**RE: NW Diagnostic Center @ Chaparral Elementary- 1700 Mae Ave. SW
Grading and Drainage Plan
Engineer's Stamp Date 12-18-2014 (File: F10D005A)**

**Re: NW Diagnostic Center @Chaparral Elementary School,
6450 Western Trail NW
Traffic Circulation Layout for Phase 2 Only (5 new portable buildings)
Engineer's/Architect's Stamp dated 01-08-15 (F10-D005A)**

RE: NW Diagnostic Center – Phase 2 @ Chaparral Elementary School
Traffic Circulation Layout (TCL) (File: F10/D005)

| DESIGNED BY   | DATE | BY  | REVISIONS  | JOB NO.       |
|---------------|------|-----|--|---------------|
| J.G.M.        |      |     |  | SHEET 5 OF 15 |

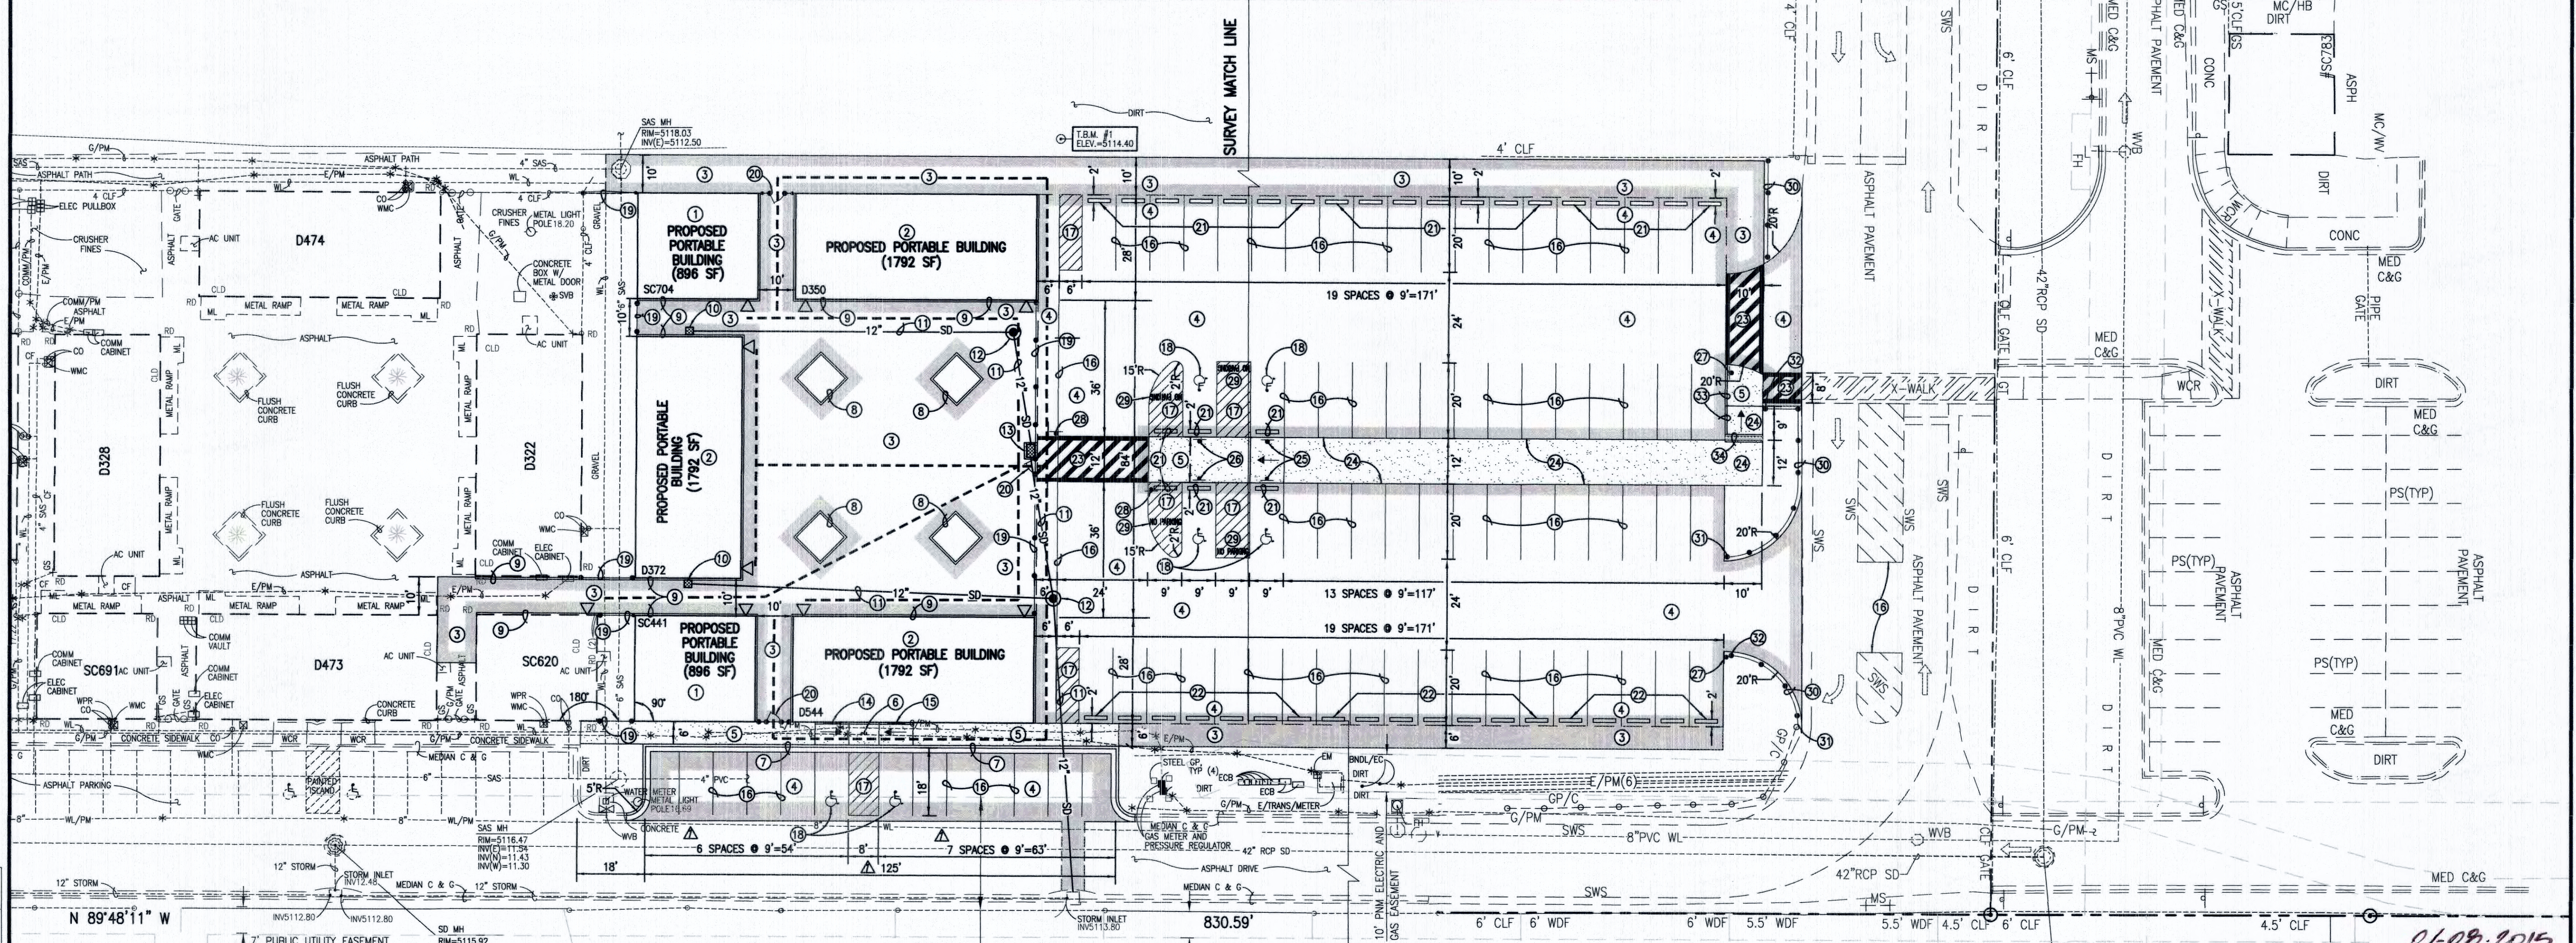
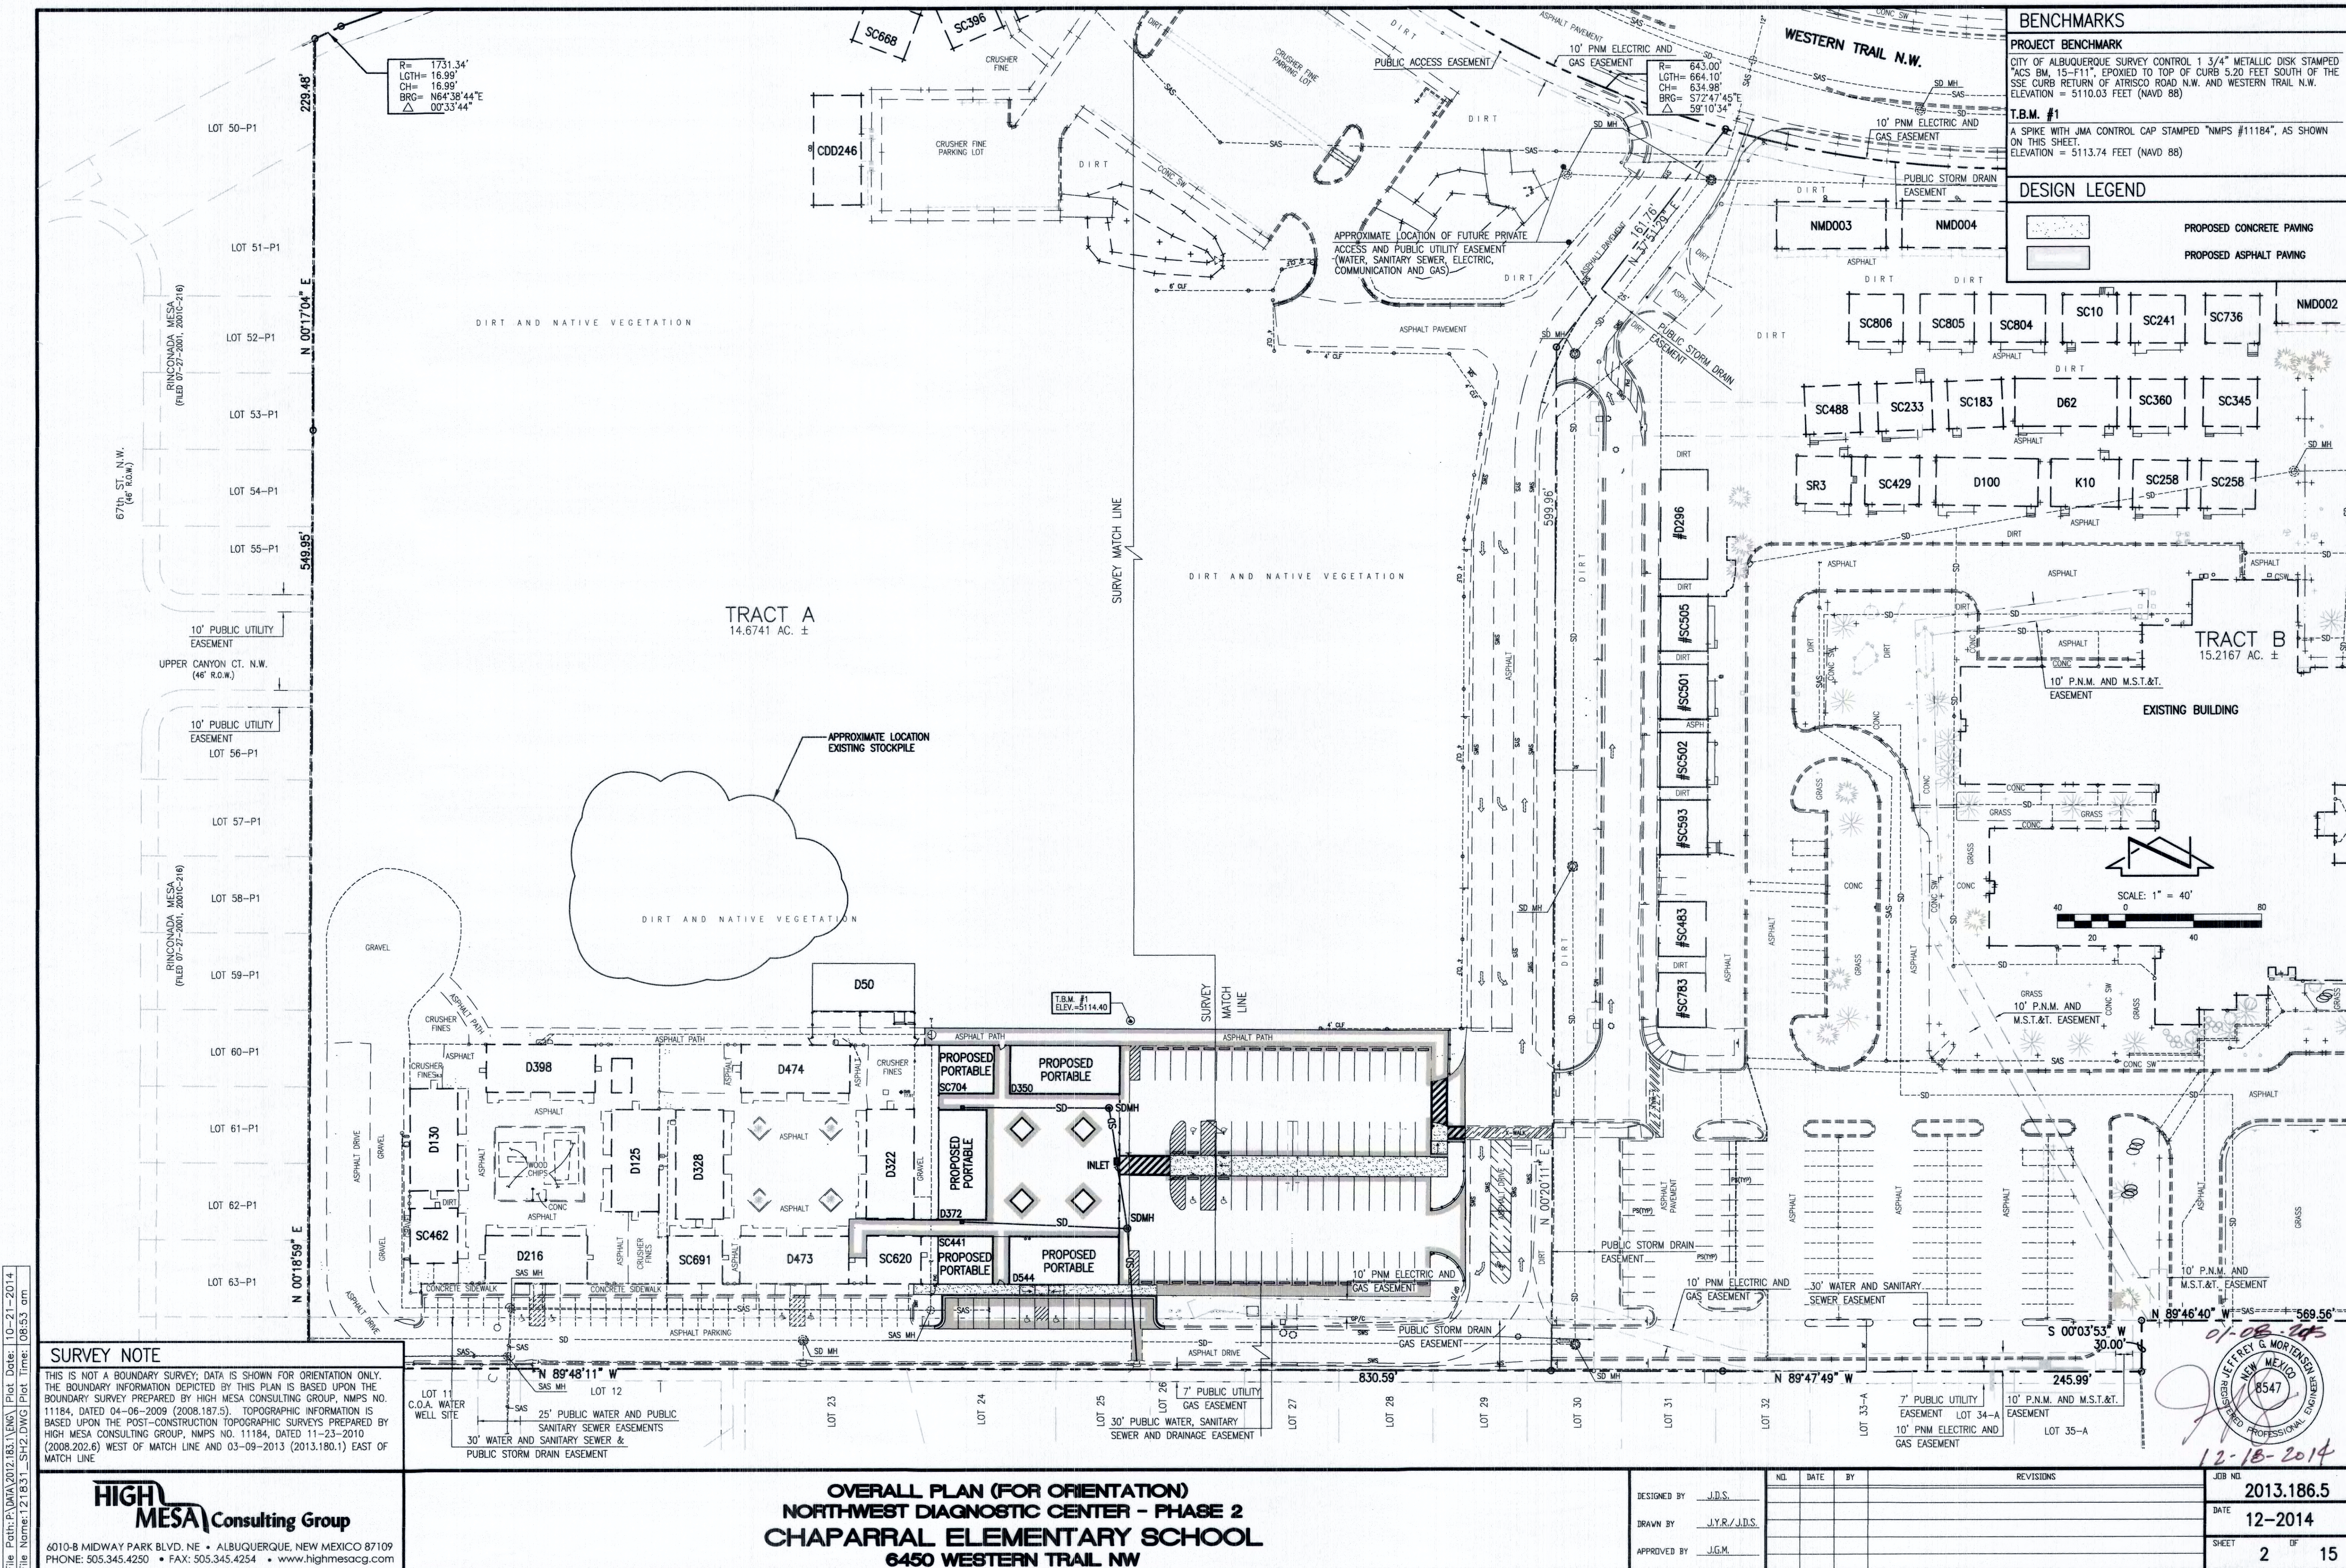
- 1) Because Sheet 5 looks like it contains the majority of the information needed to approve a TCL layout, use this as the overall TCL plan to be stamped. Please include the vicinity map on this sheet, too, and include "Traffic Circulation Layout" within the title of the sheet.

- 2) Please show parking calculations on this sheet with the number of parking spaces required by zoning code. Include existing and proposed parking spaces for the entire APS Facility.

- 3) Label the square footage of each of the new portable buildings.
 - Square footage for each portable building is now labeled on the TCL plan.
- 4) Please identify all doors entrances for the new portable building since they influence the pedestrian circulation on-site.

- 5) Please list the width and length for all parking spaces within the water and sewer easement. The handicap accessible spaces must be a minimum of 8.5 feet in width, and the van access aisle must be a minimum of 8 feet wide.

- An ADA van accessible sign detail is now shown on the TCL plan and includes the required language specified above.
- 7) Indicate the words **“NO PARKING”** within the van accessible aisles shall be at least one foot high and at least two inches wide. (66-1-4.1.B NMSA 1978).

- 9) For all keyed note call-outs on the TCL Layout (Sheet 5) referring to details on Sheet 6, call out the exact number of the detail to be clear.
 - All keyed note call-outs on the TCL Layout that refer to Sheet 6 details now include the exact number of the detail and section for clarity.

- 10) Some of the new parking spaces are within the ABCWUA 30-foot easement along with the existing parking spaces. Do you have existing easement language that you can provide in your next submittal indicating that it is acceptable to build parking spaces within the easement? If not, an agreement with the ABCWUA needs to be arranged. Contact Kris Cadena of the ABCWUA (924-3988).

- Sheet 5 (hence referred to as the TCL plan) has been revised to include the addition of "Traffic Circulation Layout" to the sheet title. Due to the additional information requested in the comments below, there is no available space for a Vicinity Map on this sheet. Therefore the Vicinity Map remains on the TCL submittal cover / index of drawings sheet.

- Parking calculations are not included herewith as APS sites are not subject to the zoning code. The APS Department of Facilities Design and Construction reviews and approves the parking layout, number and types of parking spaces provided for each project site on a case-by-case basis.

- All portable building entrance locations are now identified on the TCL plan.

- All parking space width and lengths on the south side of the project are labeled and meet or exceed the minimum dimensions identified above.
- 6) Include a detail for the ADA van accessible sign. The ADA van accessible sign must have the required language per 66-7-352.4C NMSA 1978 **“Violators Are Subject to a Fine and/or Towing”**

- Minimum lettering height and width dimensions have been added to the **“NO PARKING”** keyed note (Note #29) on the TCL plan.
- 8) Per the DPM, a 6 ft. wide ADA accessible pedestrian pathway is required from the HC parking stall access aisles to all of the building entrances. Please clearly show this pathway and provide language showing that it shall be a 2% maximum required cross-slope. Label the required dimensions for asphalt walkways between buildings, using a minimum dimension of 6 feet when providing ADA access to door entrances.

- There is no existing easement language regarding parking space construction within the easement. This has not been an issue in the past on APS sites; prior submittals for Phase 1, which included the existing parking spaces, were approved by both the Transportation Development Services Engineer and the City Engineer. A phone conversation between Justin Schara and Kris Cadena on January 7, 2015, confirmed that no additional easement language is required by the ABCWUA for this project.
